Historic England

Our ref: P00715770

22 March 2018

**CO-OP BUILDING, 103 NEW STREET, HUDDERSFIELD, WEST YORKSHIRE, HD1
2TW
Application No. 2017/93886**

Drawing Title: Proposed Queensgate Elevation

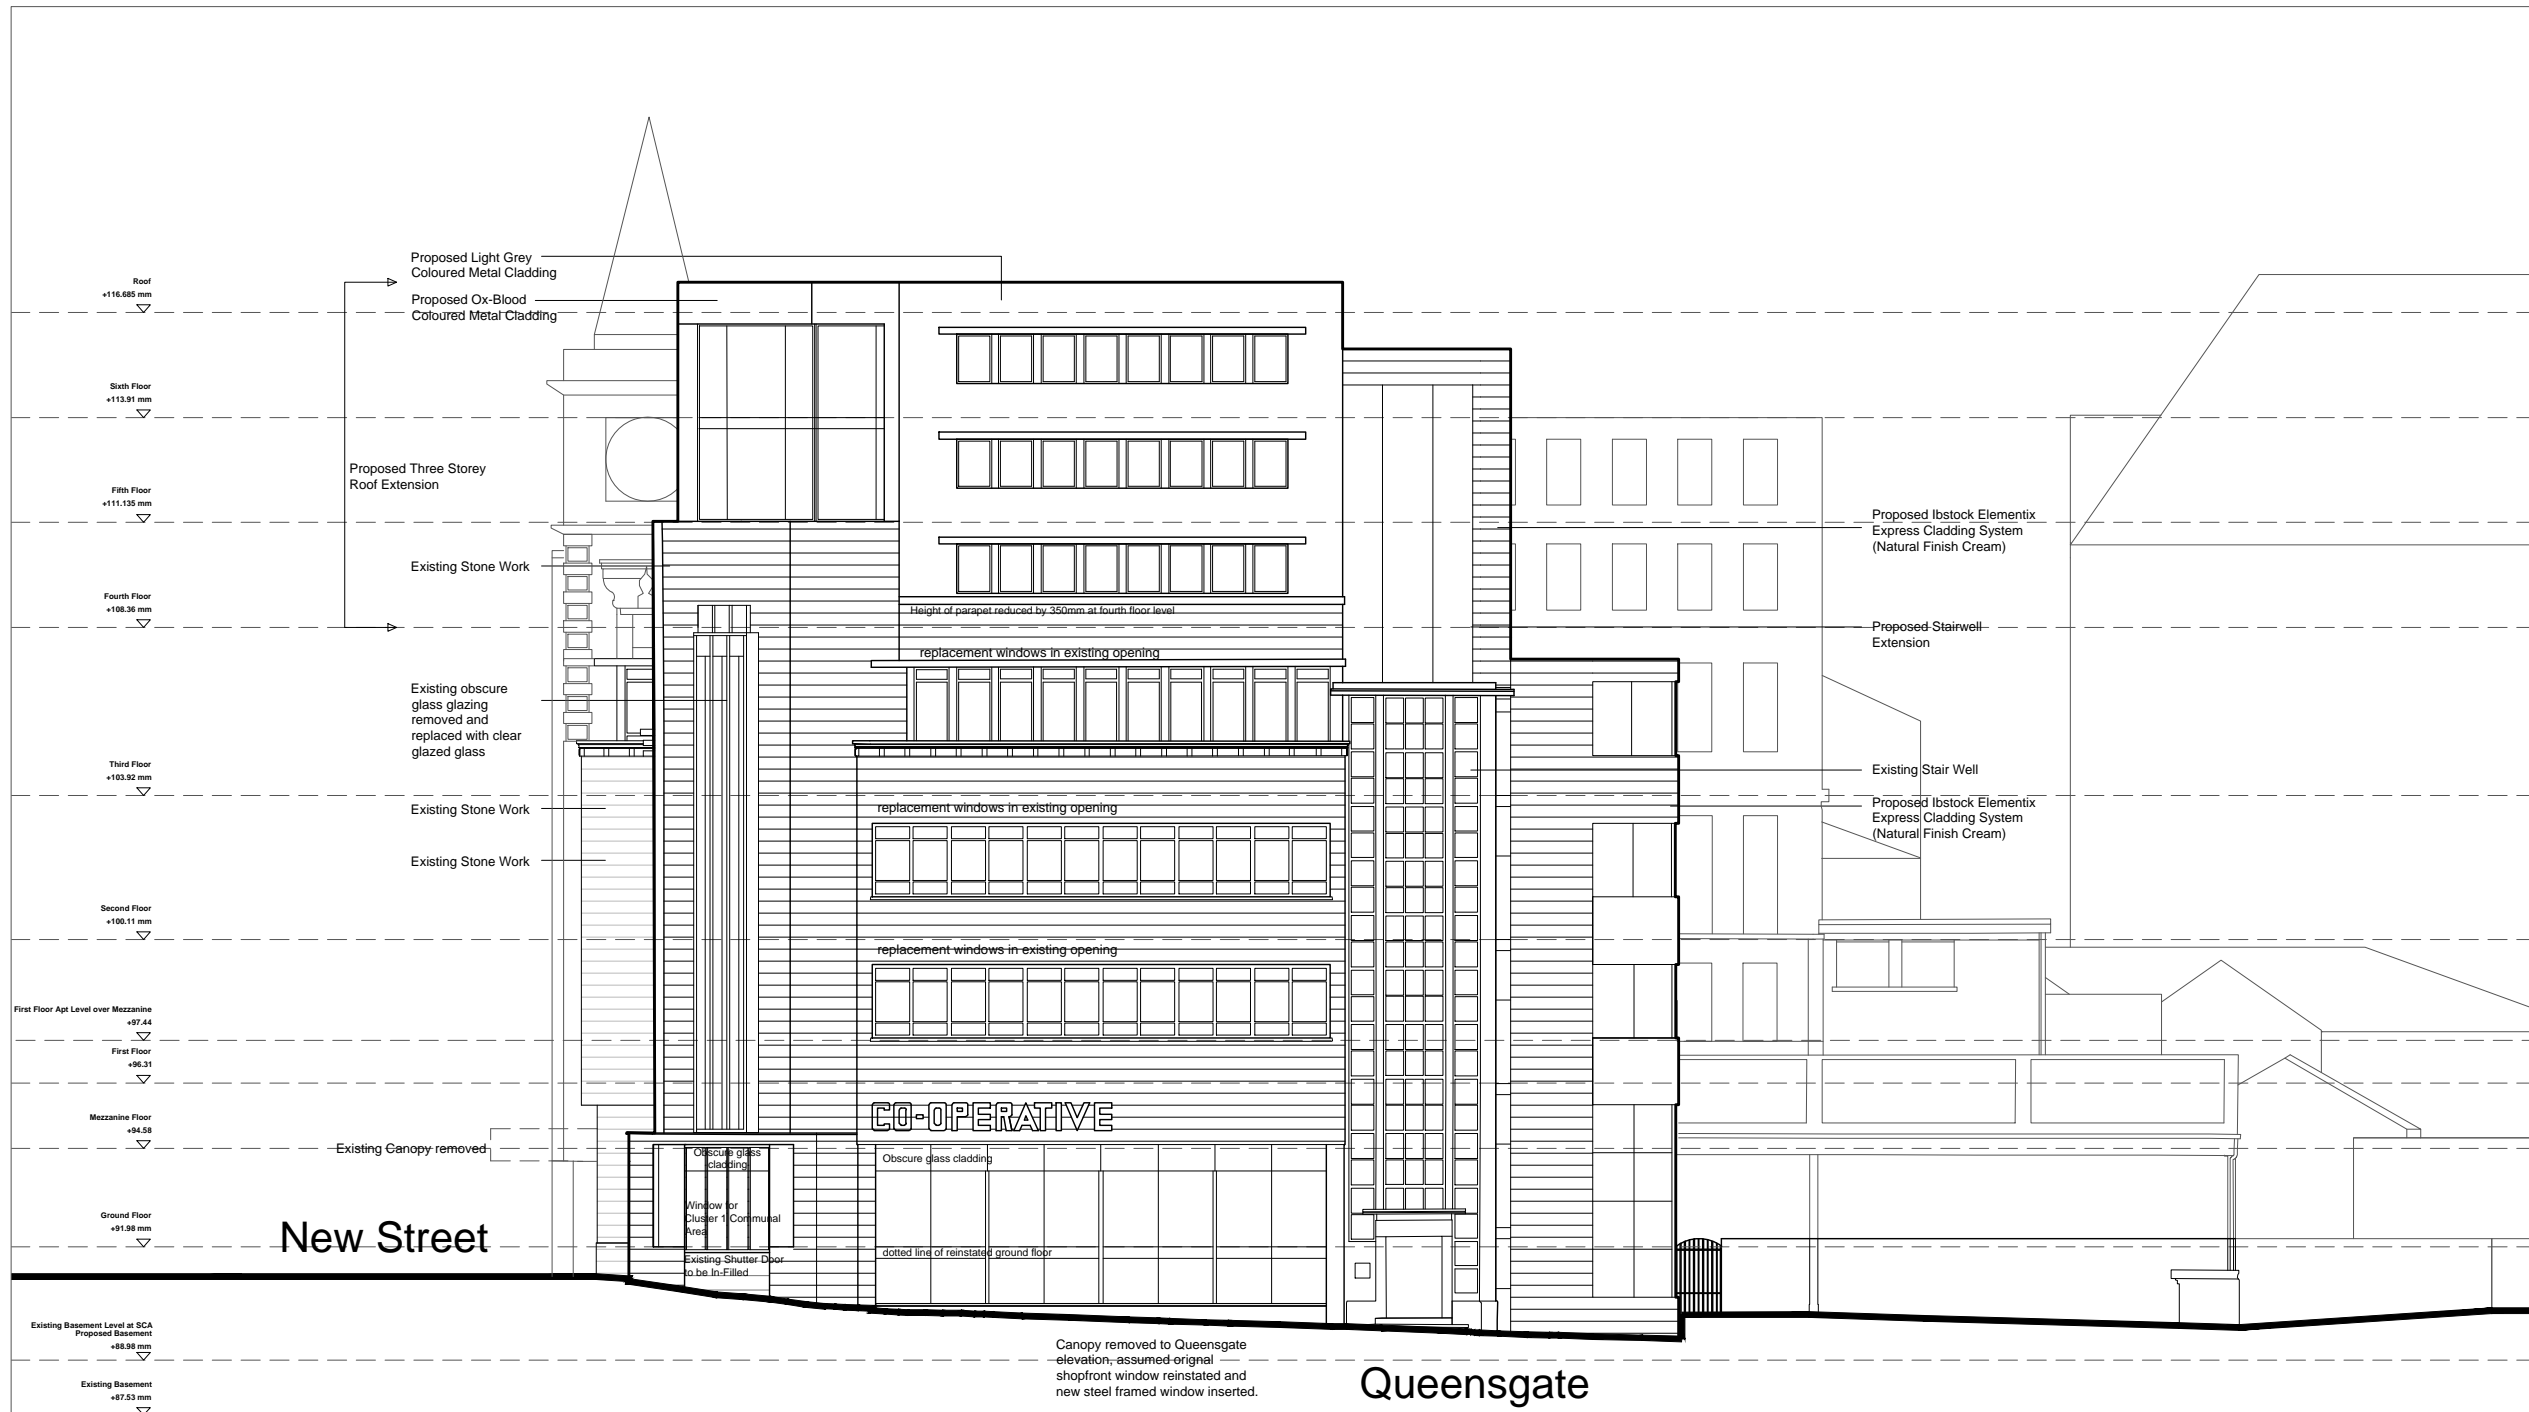
The proposed design of the windows on the rooftop extension has been amended which we welcome. However, the size of the rooftop extension at three storeys is still of considerable concern. Given that this aspect of the proposals would be harmful to the conservation area and the setting of the adjacent listed buildings, your authority should be satisfied that the viability of the scheme constitutes the "clear and convincing justification" which is required for this harm by paragraph 132 of the National Planning Policy Framework.

We previously advised that the impact on the surrounding heritage assets could be further reduced through attention to details and materials. We therefore welcome the changes to the window design. We note, however, that the extension is still proposed to be clad in grey metal cladding with red accents. We recommend this is amended to a darker tone cladding, ideally a dark bronze colour as is seen in a number of other buildings in the conservation area and which tones better with the stonework of the Co-Op building and the surrounding listed buildings.
